**ADC Planning Consultation
Conservation/Design Officer Response**

Application Number	AB/73/17/HH
Address	19 Bond Street, Arundel
Description	Rooflight to an outbuilding within the curtilage of a listed building and a conservation area
Case Officer	Anita Gardner
Date	12 July 2017

PROPOSED ELEVATION (OUT BUILDING) 1:50.

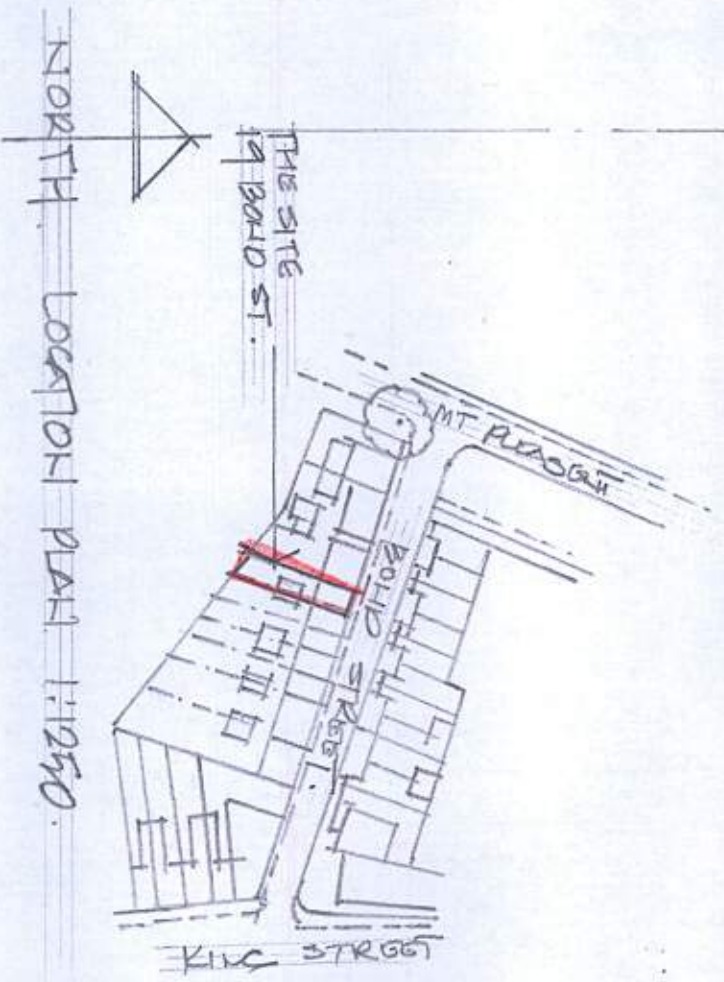
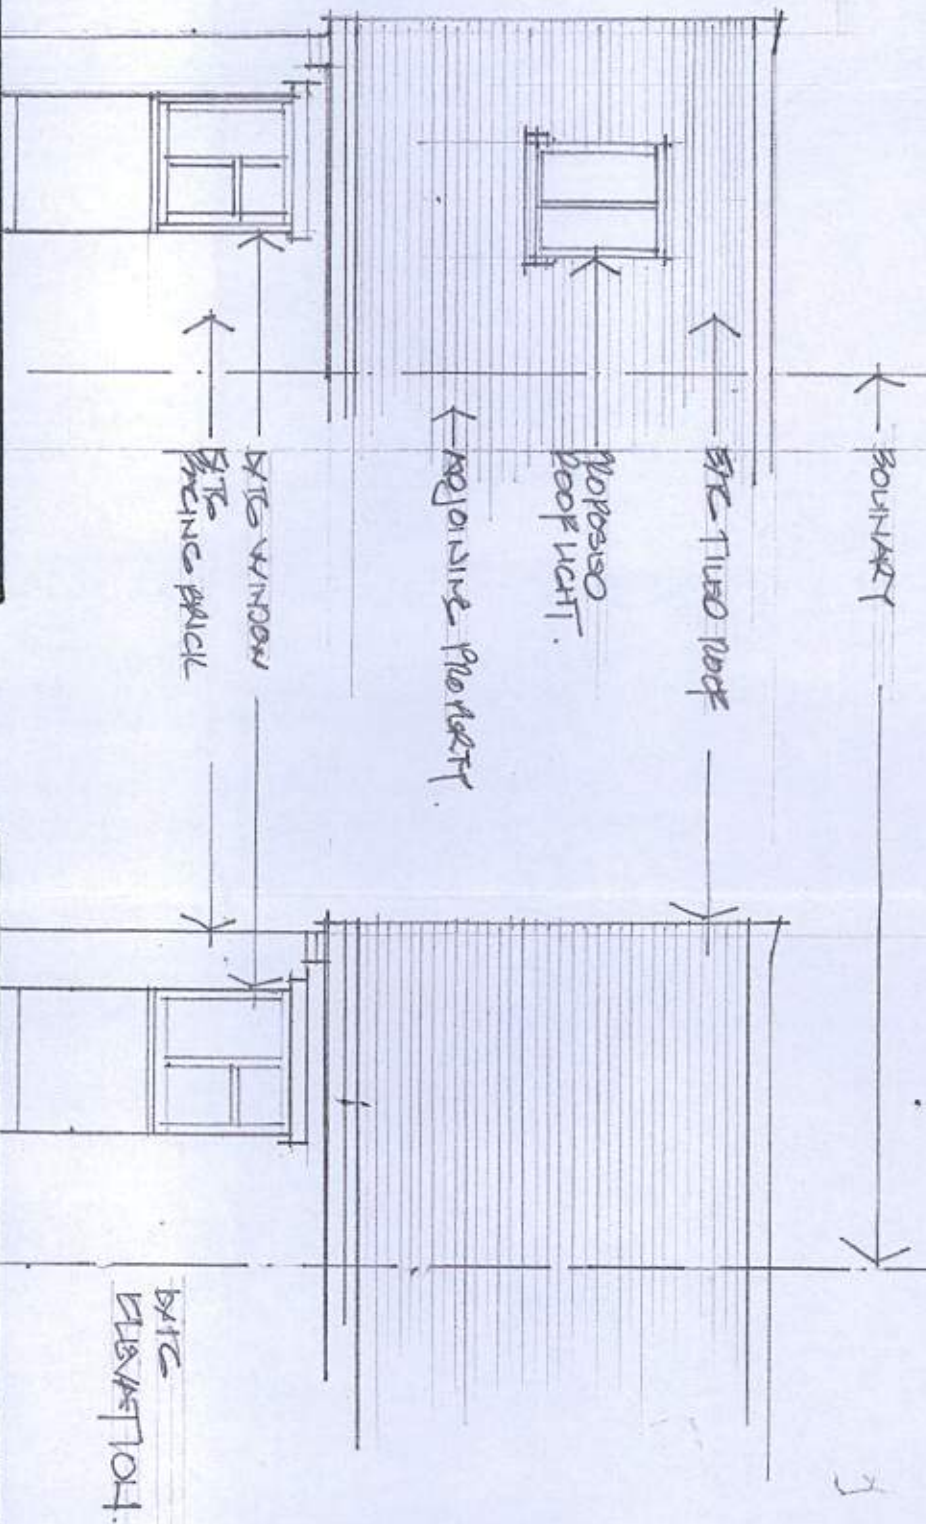
Installation of a conservation rooflight to the southern roofslope of the outbuilding to the rear of the listed terrace causes no harm to the significance of the adjacent listed buildings, and no harm to the significance of the conservation area.
